Our ref: MP 10\_0107

### **Major Project 10\_0107 – Residential Development Buildings 1, 2 & 3, 61 Mobbs Lane, Epping**

### ADDITIONAL INFORMATION REQUIRED

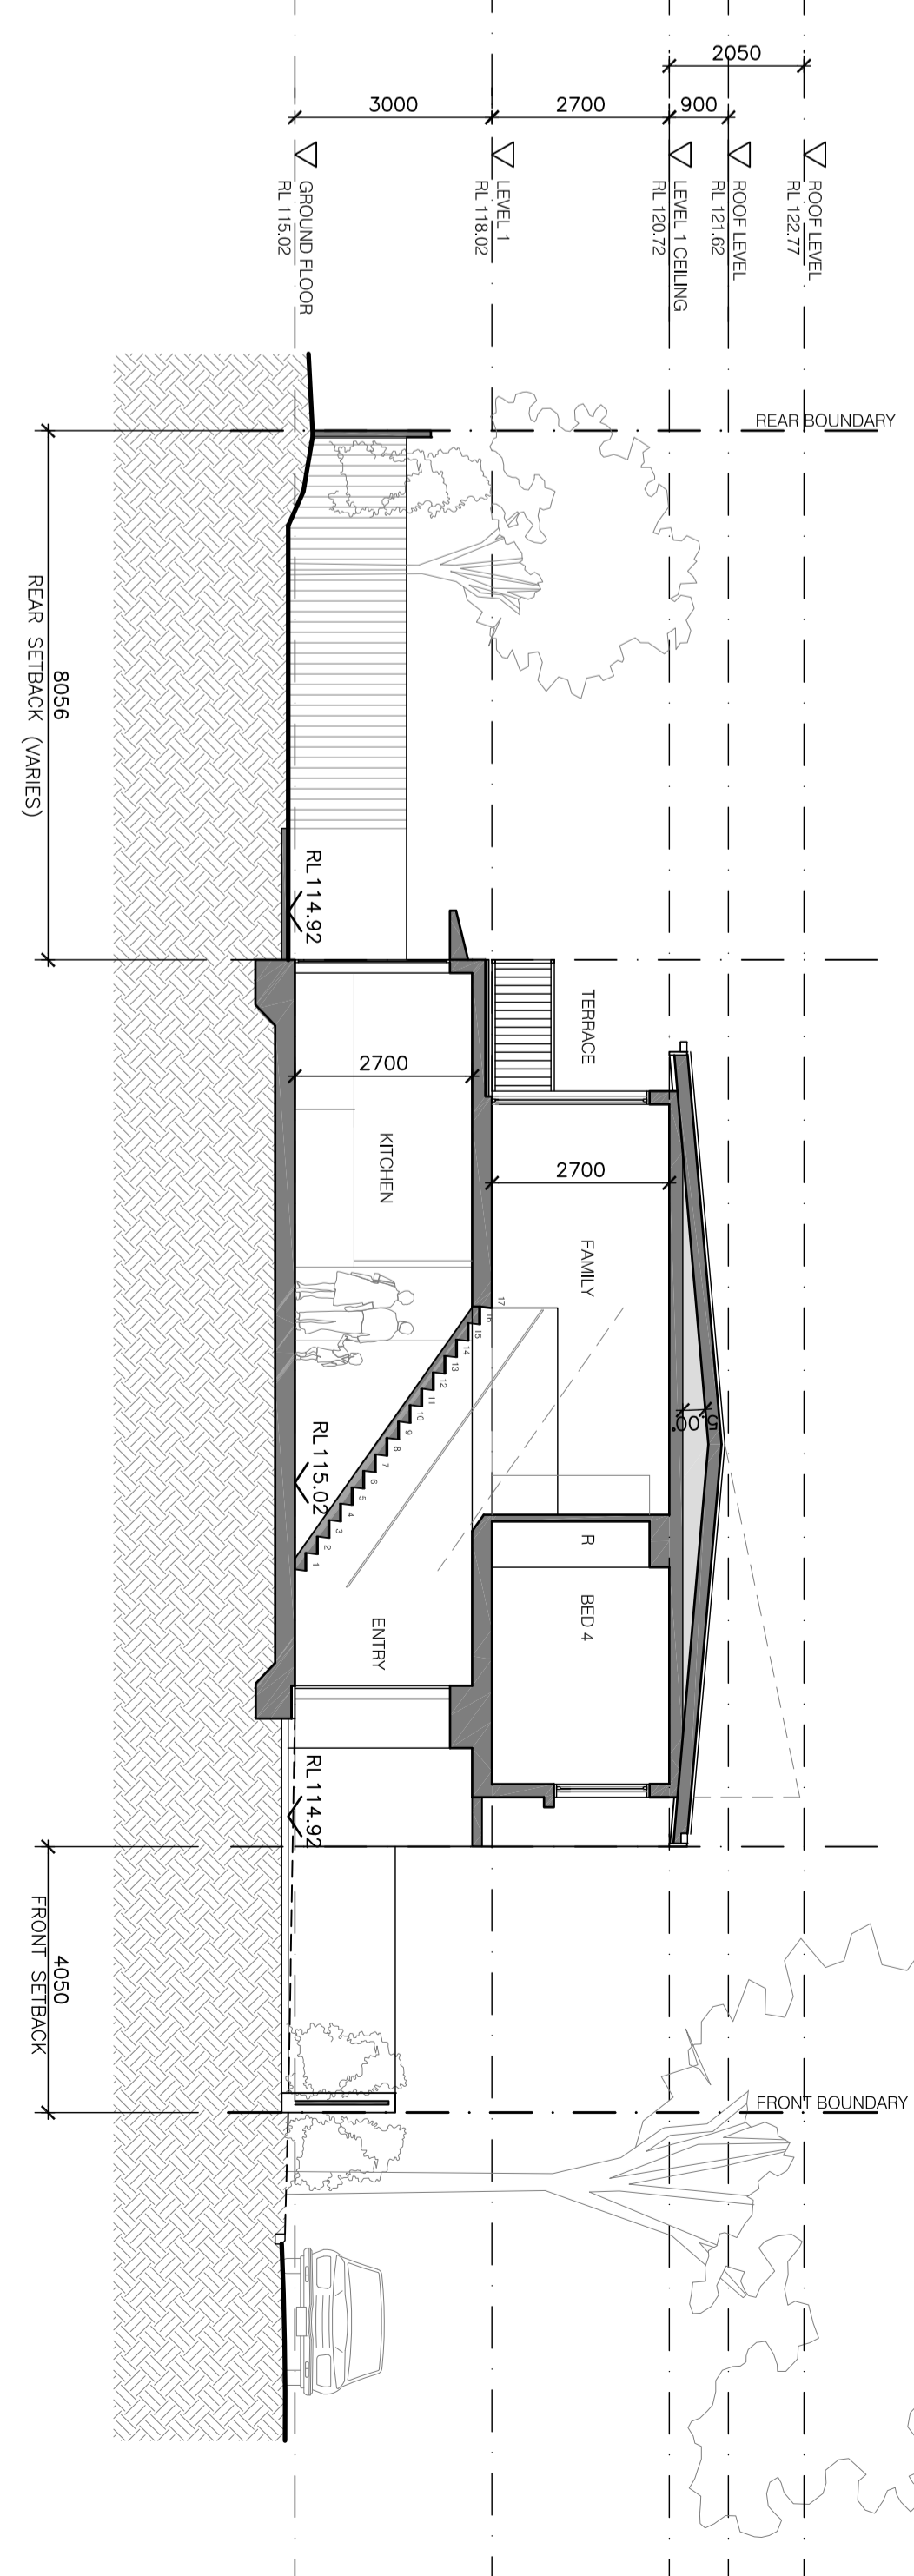
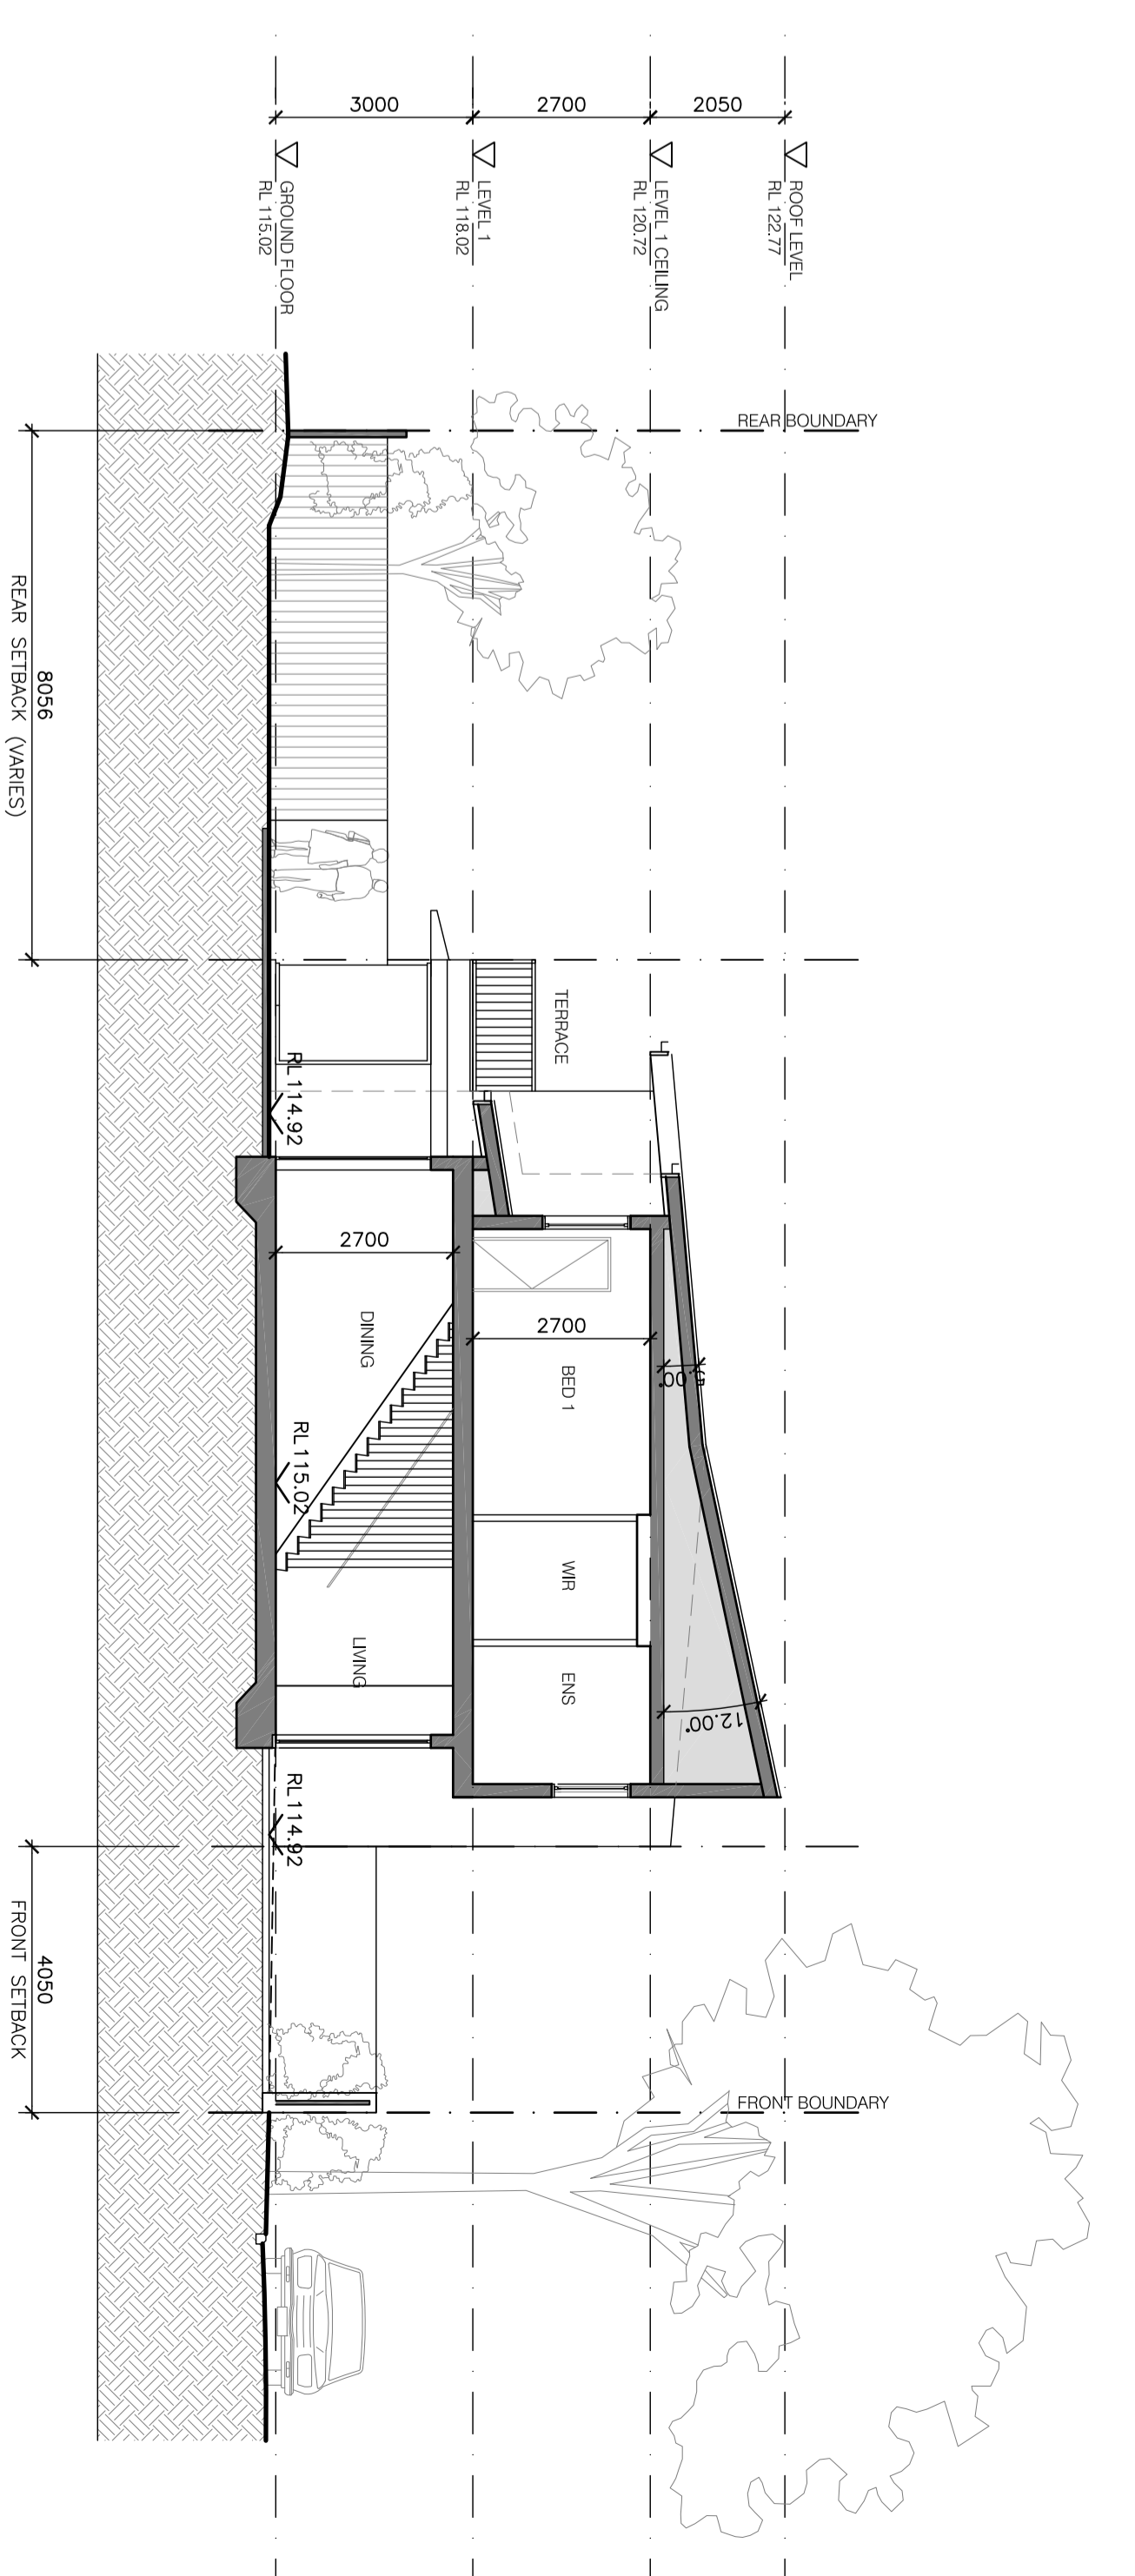
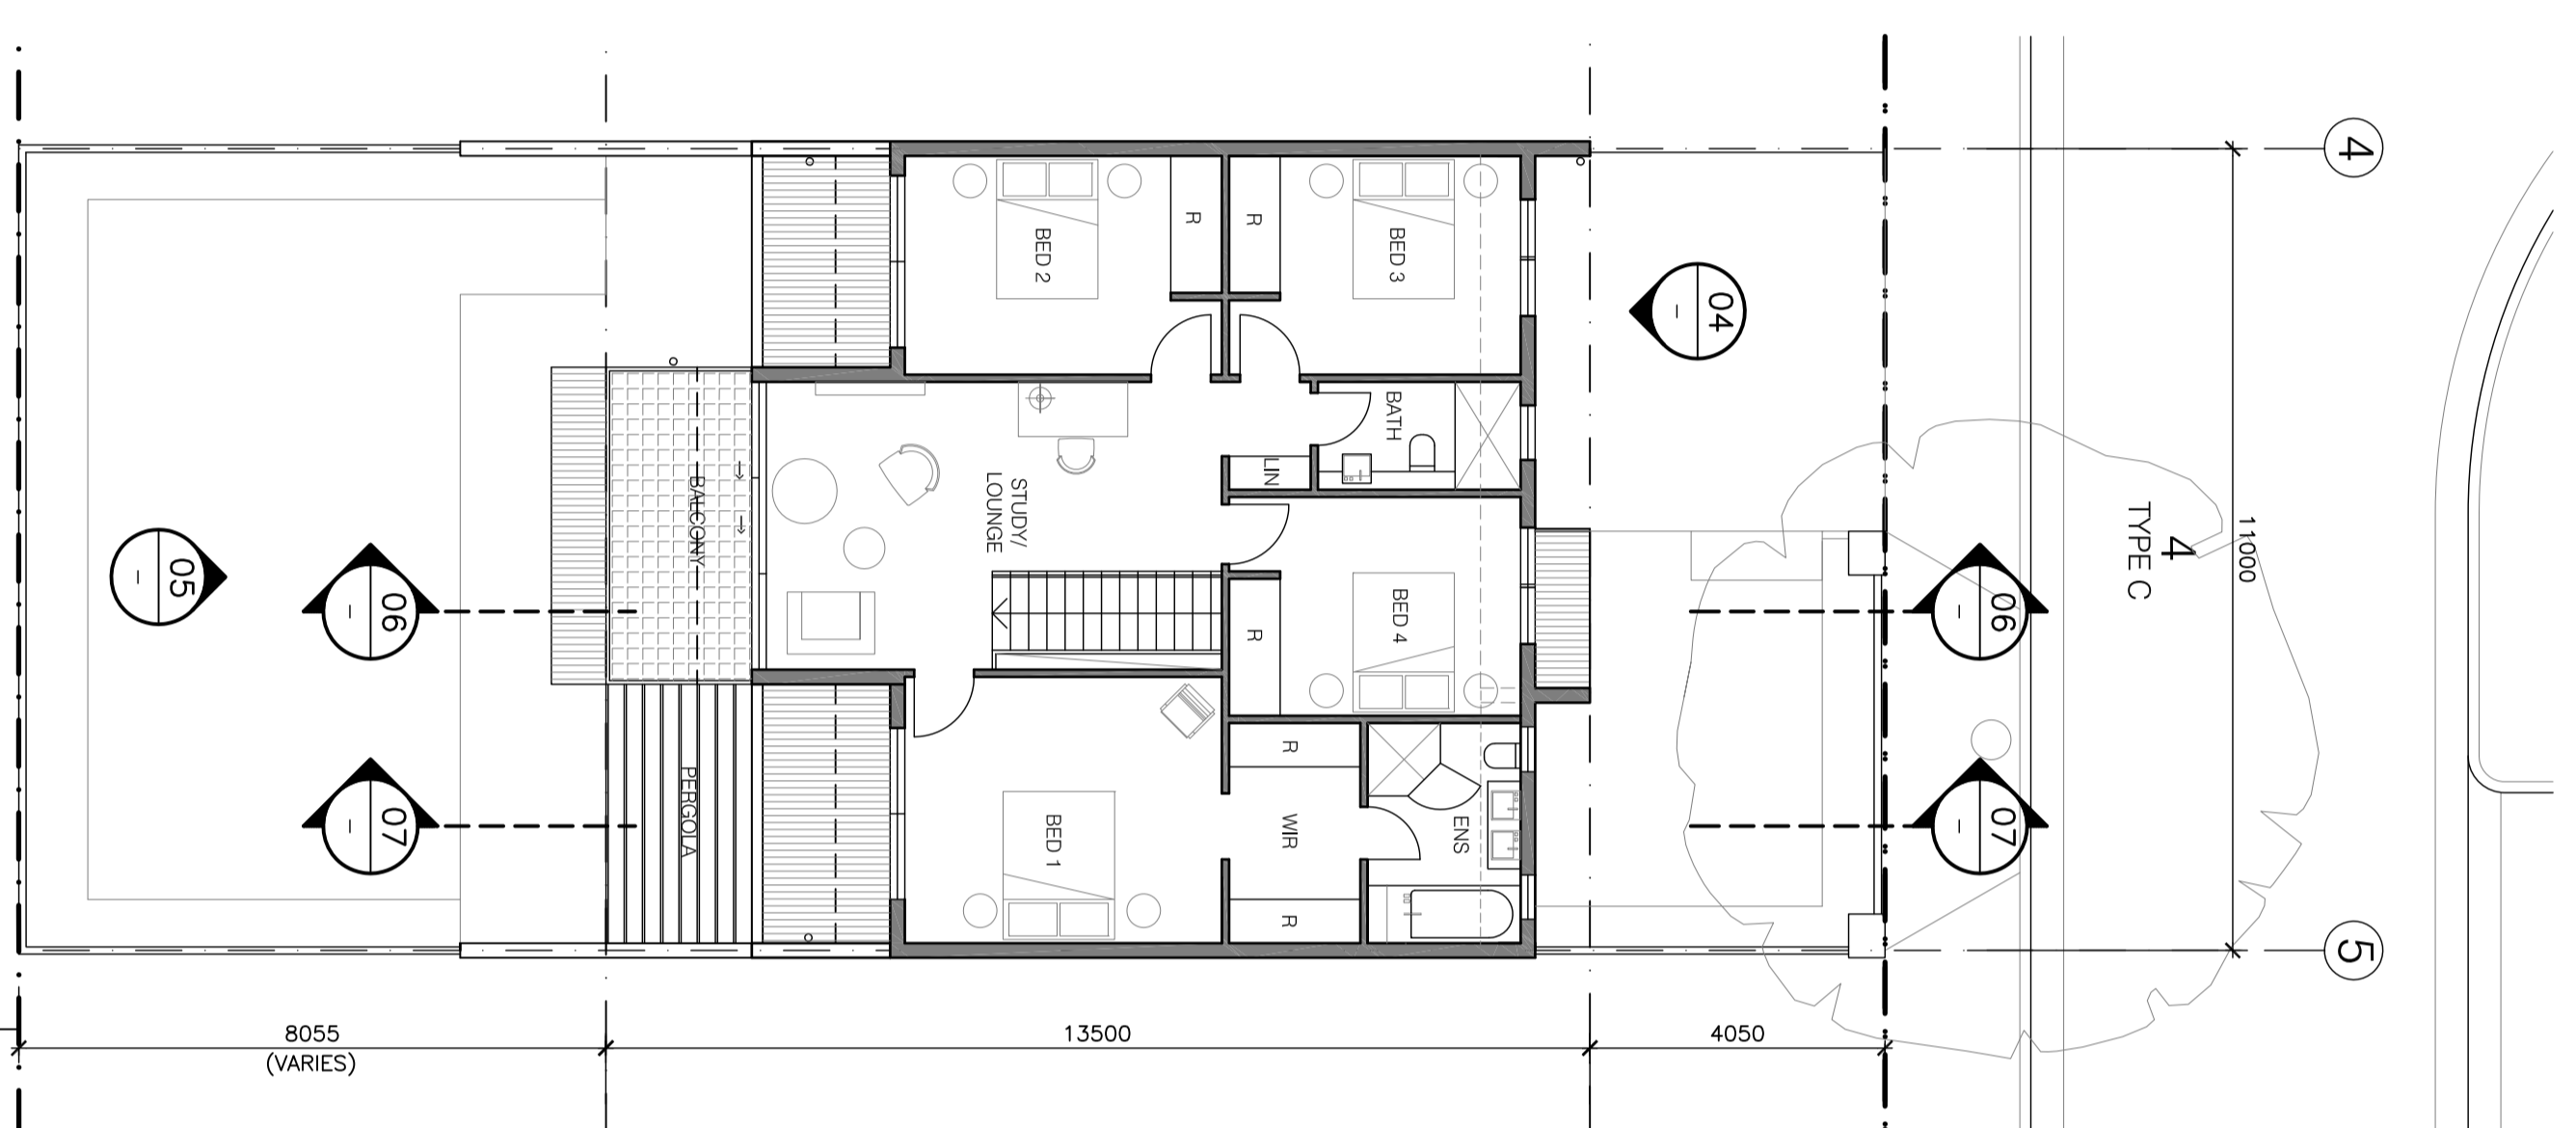
#### **1. Usability of Private Open Space to Building 3**

Consideration should be given to increasing the usability of the rear private open space to those dwellings within Building 3 which experience significant changes in levels.

#### **3. Adaptability**

Confirmation is requested as to the potential compliance of the dwellings within Building 3 with AS 4299 Adaptable Housing.
